DECISION DELEGATED TO HEAD OF PLANNING

Application No: H01-0733-24 **Applicant:** Mr C Harris
Proposal: Proposed extension & alterations
Location: 32 The Pastures Cowbit Spalding
Terminal Date: 22nd October 2024

CASE OFFICER ASSESSMENT

Drawing Planning (floor and elevation plans)

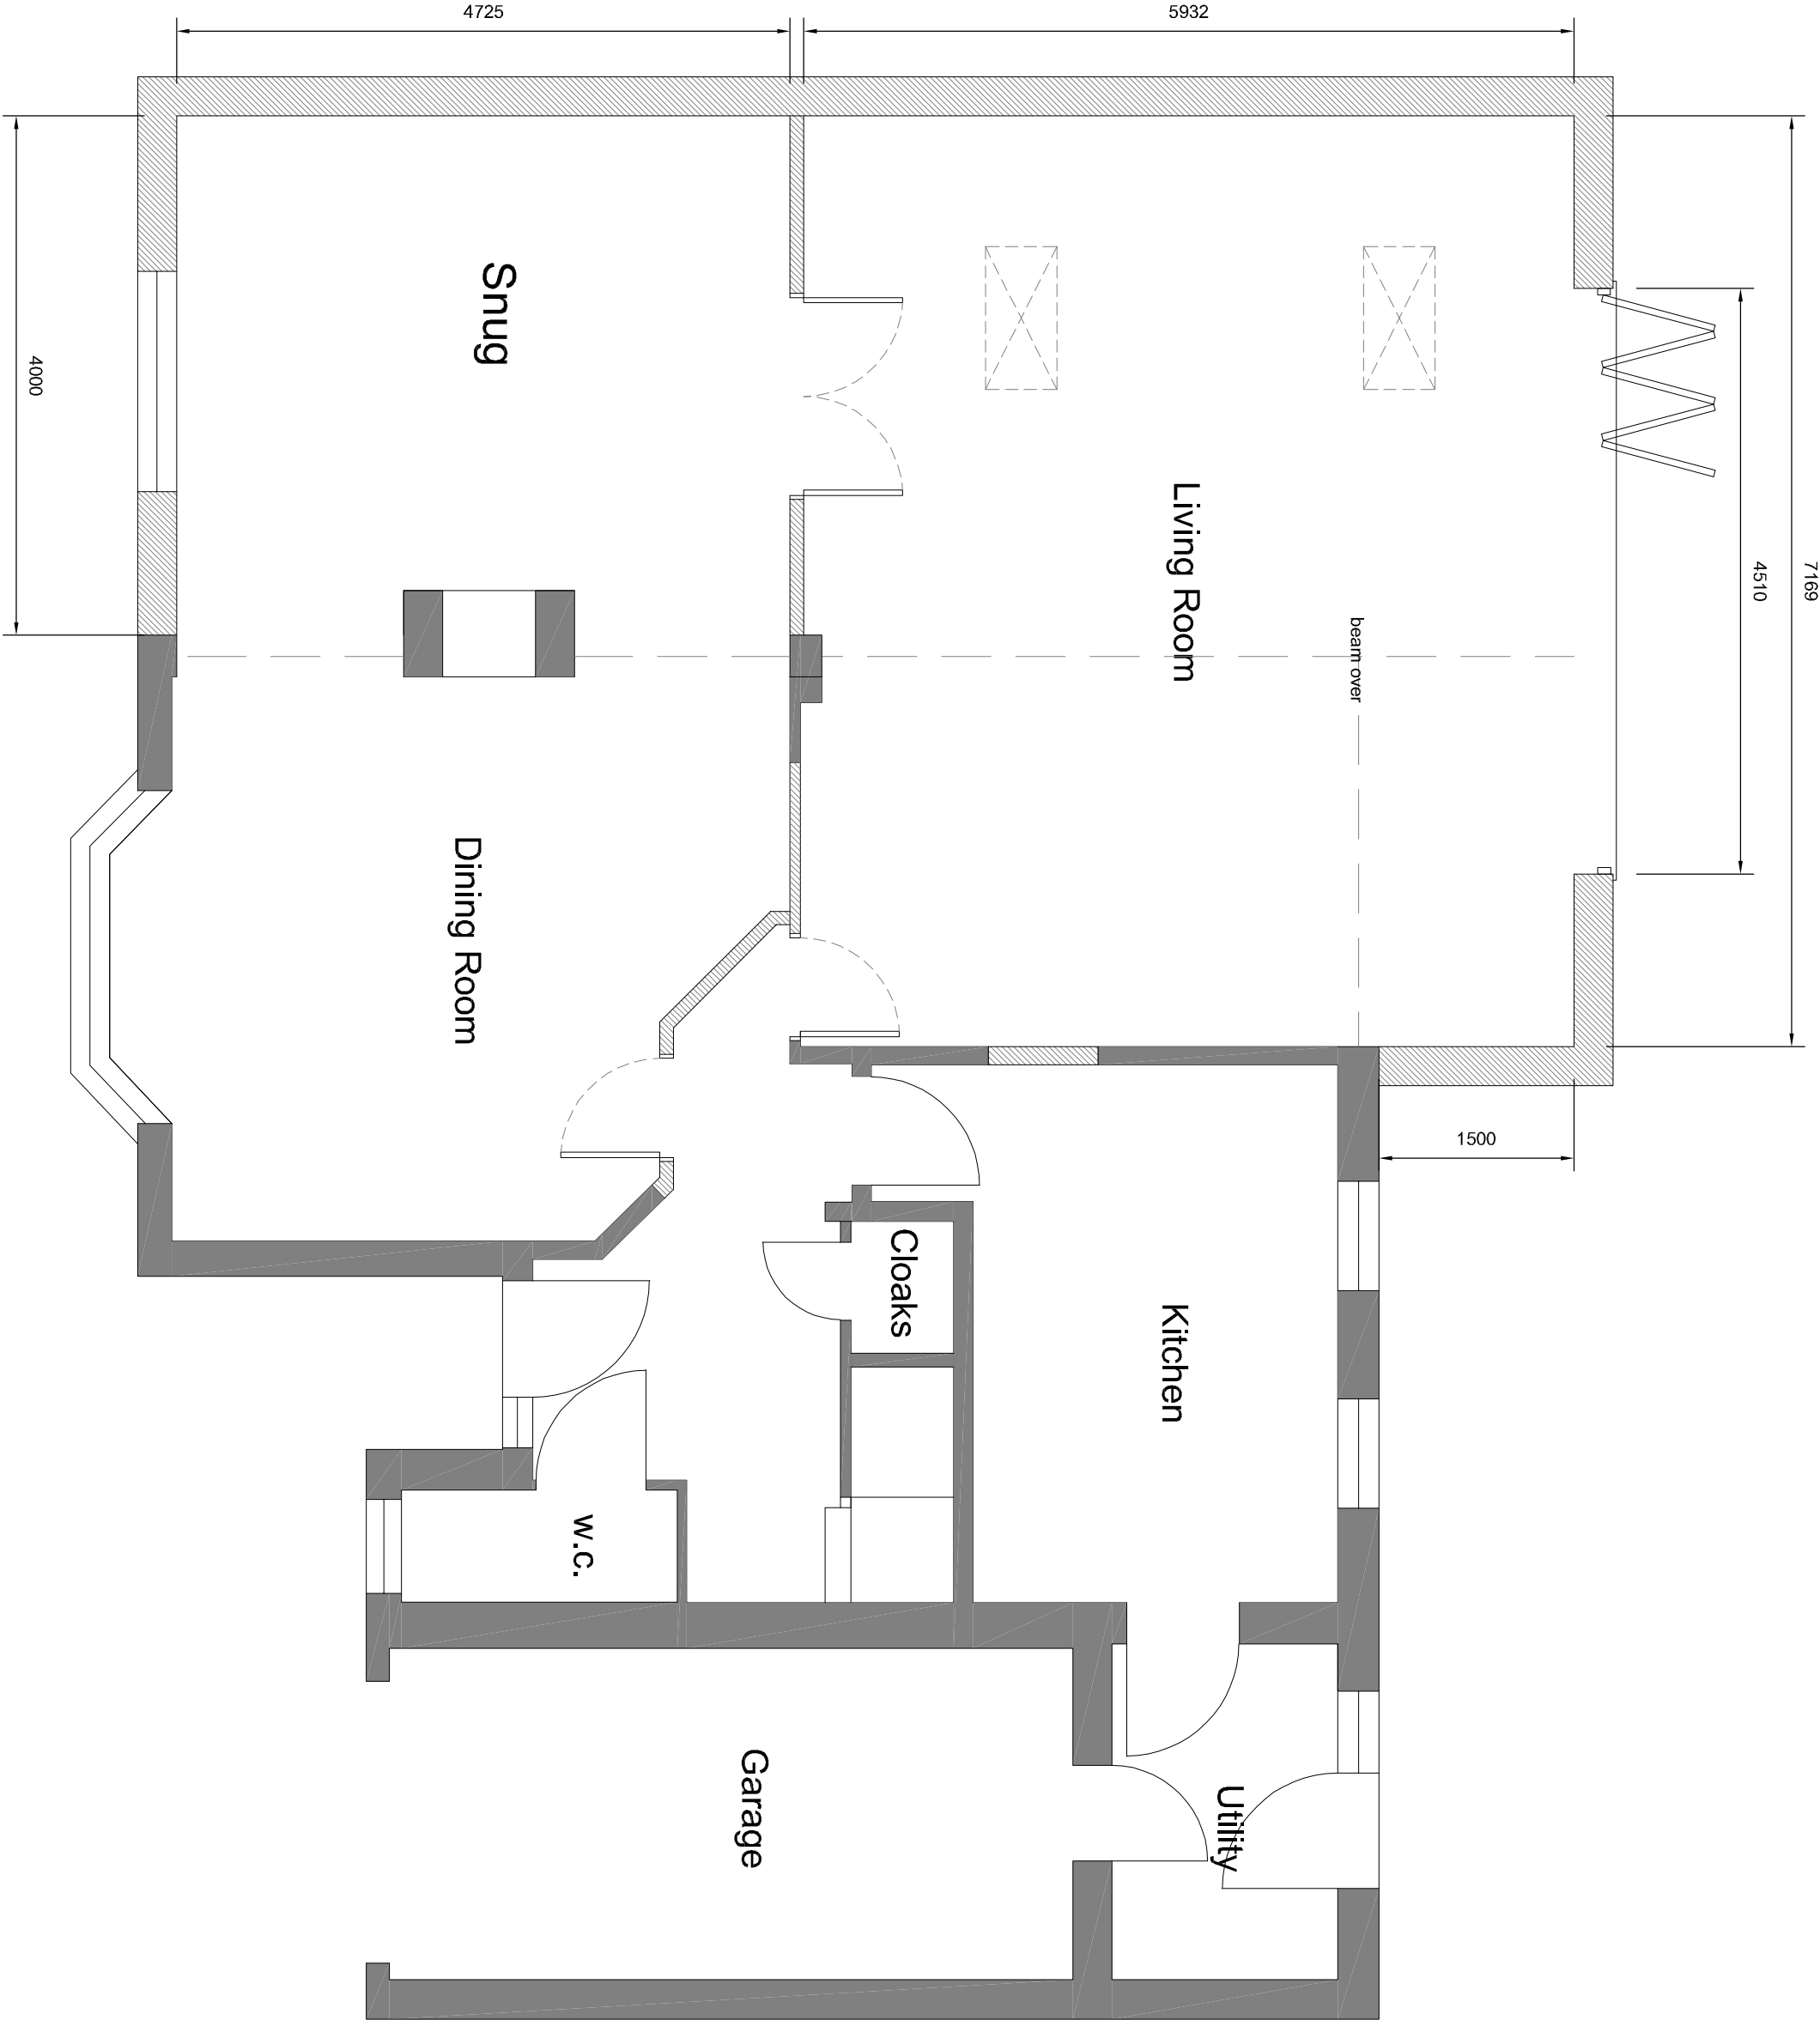
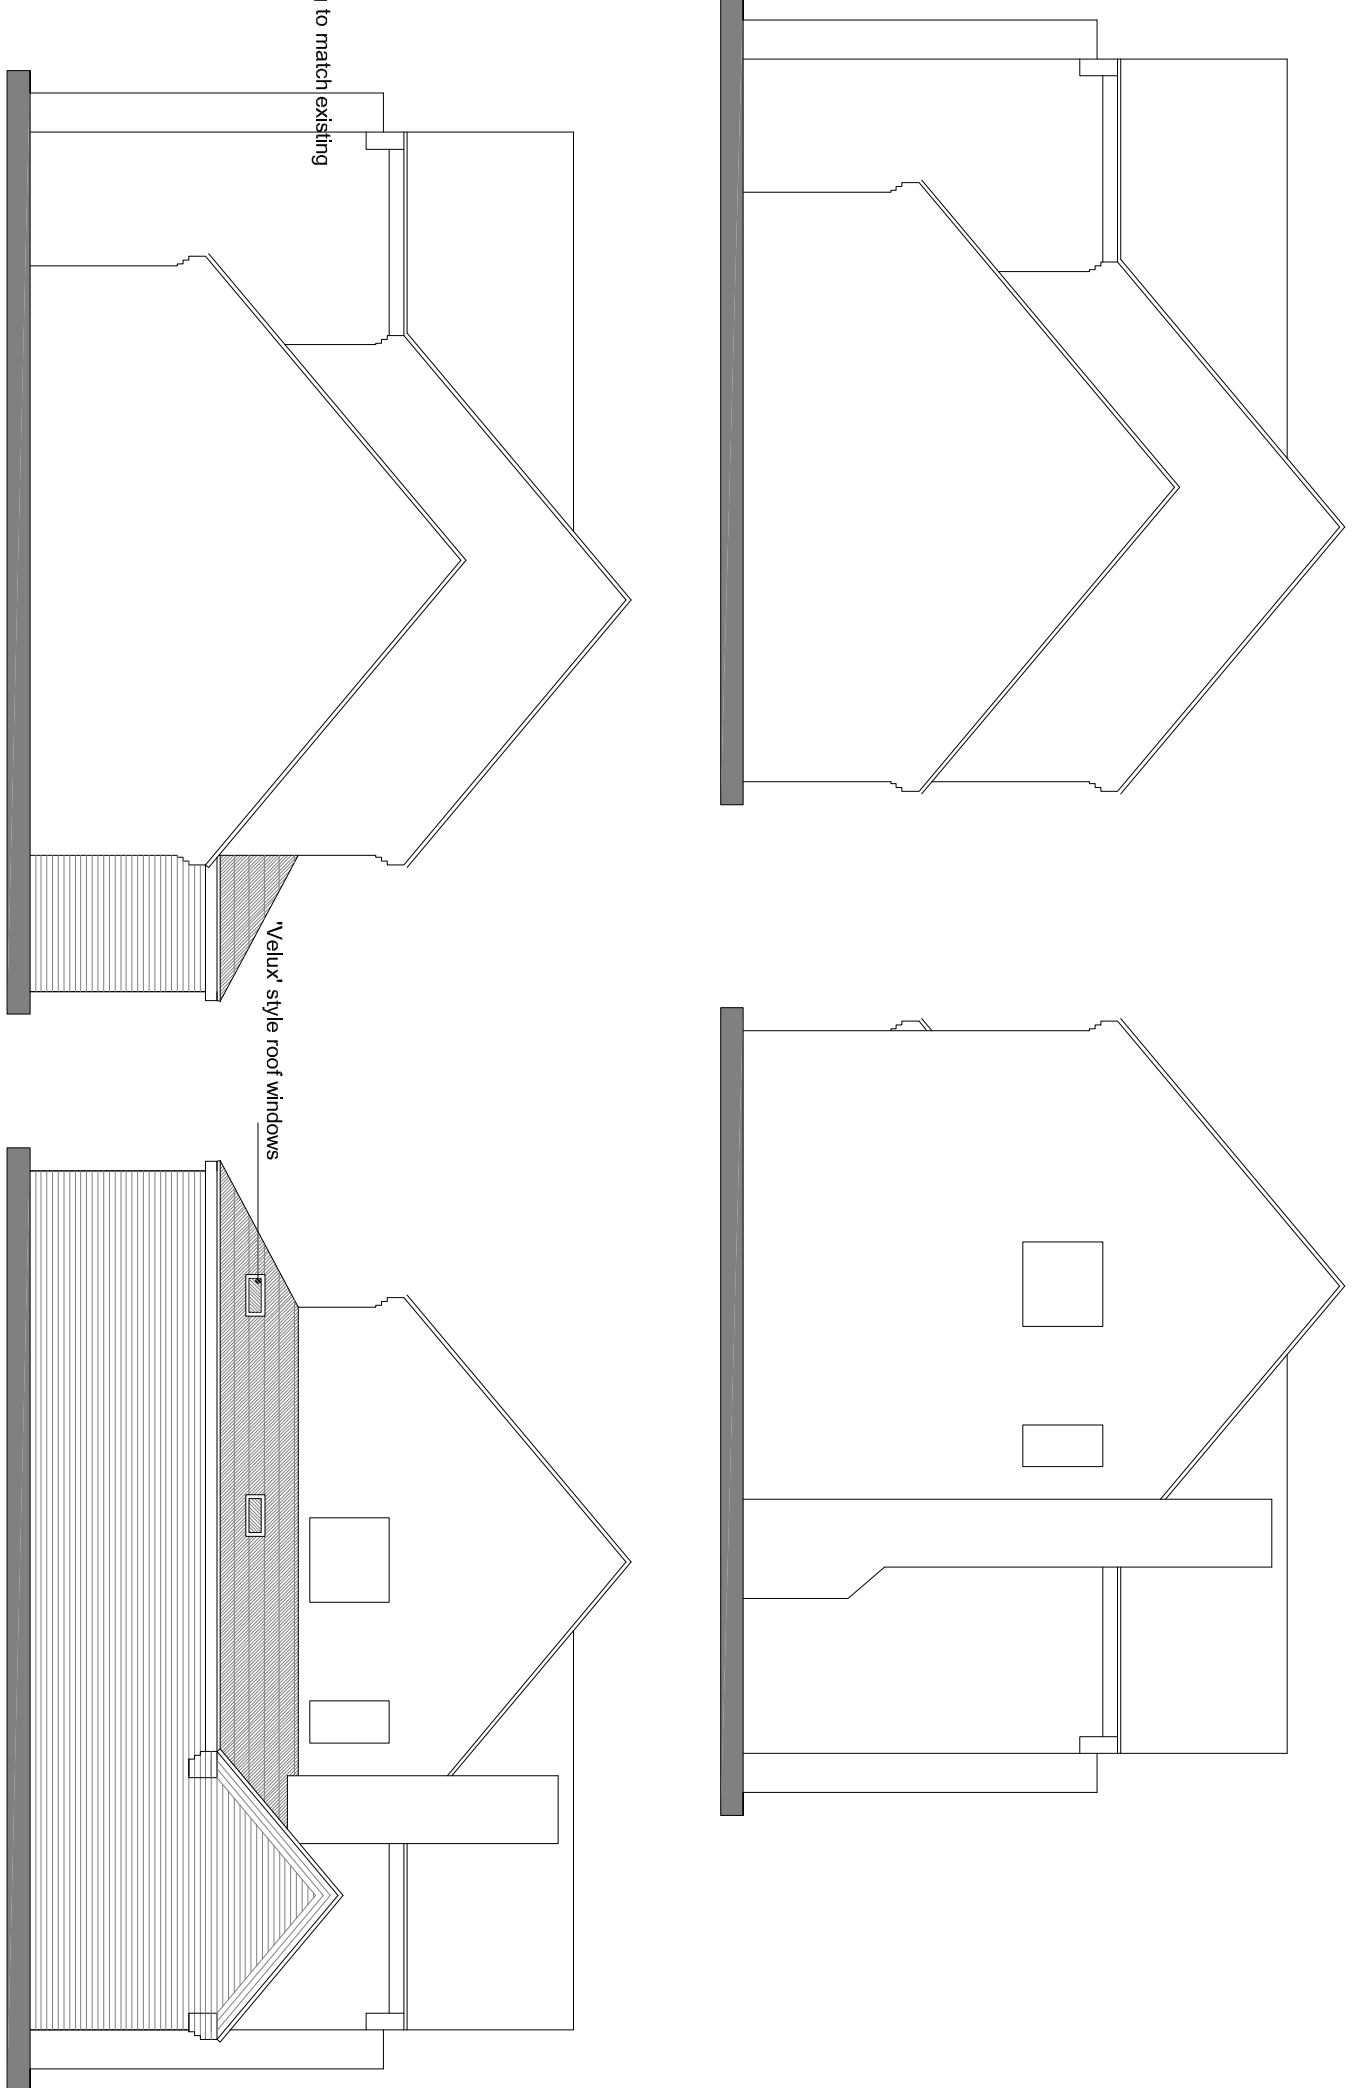
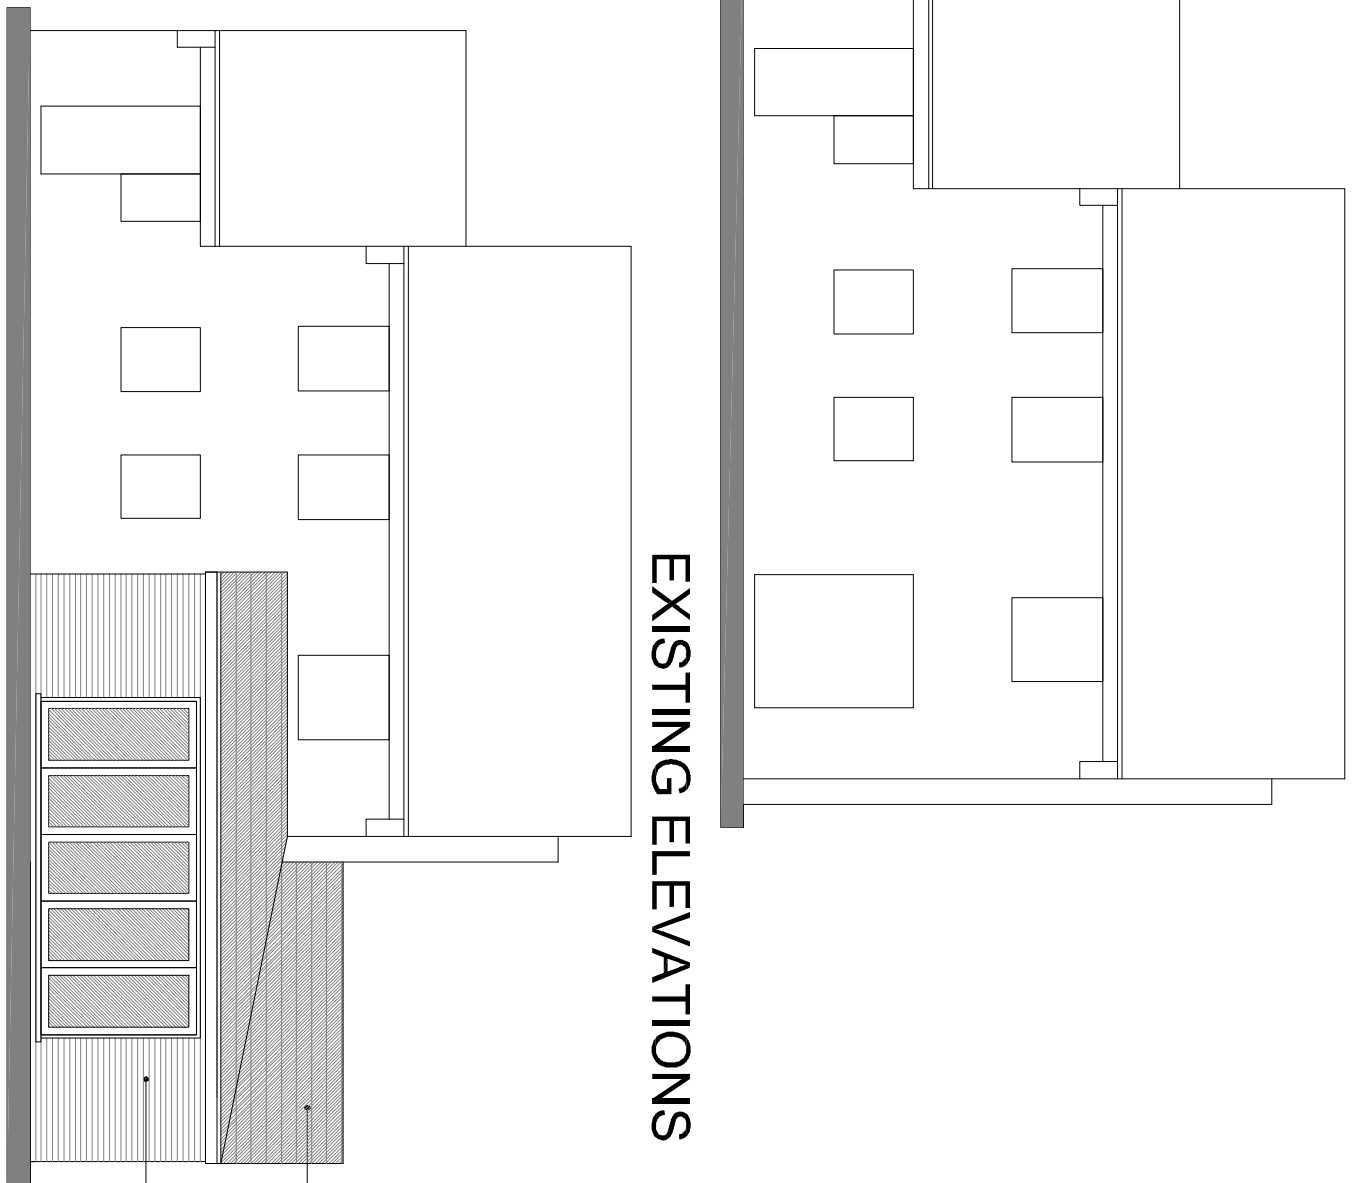
The proposed extension will match the existing materials throughout which ensures the development remains in keeping with the host property and the character of the area. They will use facing brickwork, roof coverings, cream uPVC windows and doors and this includes the existing. There will also be Velux style roof windows within the extension.

It shall protrude from the side by around 4300mm and will have a full length of 11360mm spanning from the front elevation and sticking out slightly by around 1800mm to the rear. The rear width will be around 7700mm and will feature bi-fold doors for access into the garden. As the extension is only single storey, the height will be around half of the existing dwelling being 4100mm to the ridge and 2500mm to the eaves. This extension will be proportionate in relation to the host dwelling and is smaller in scale than the previous approval further outlining its acceptability and suitability.

There are some internal alterations being carried out as part of the proposal, the living room will be converted to a dining area with the extension adjacent to this being a snug. The dining room to the rear of this will not act as a living room and opened up into the extension as well. These alterations are considered to be acceptable and will not harm the street scene or locality as they are purely internal changes only.

There are no side elevation windows within the extension with windows only being set on the front and rear elevations - due to the positioning of the extension and the windows there is no material overlooking that will occur as a result of the development being carried out. Furthermore, as the extension is only single storey and there are more than adequate distances between other properties there should be no material overshadowing to surrounding neighbours.
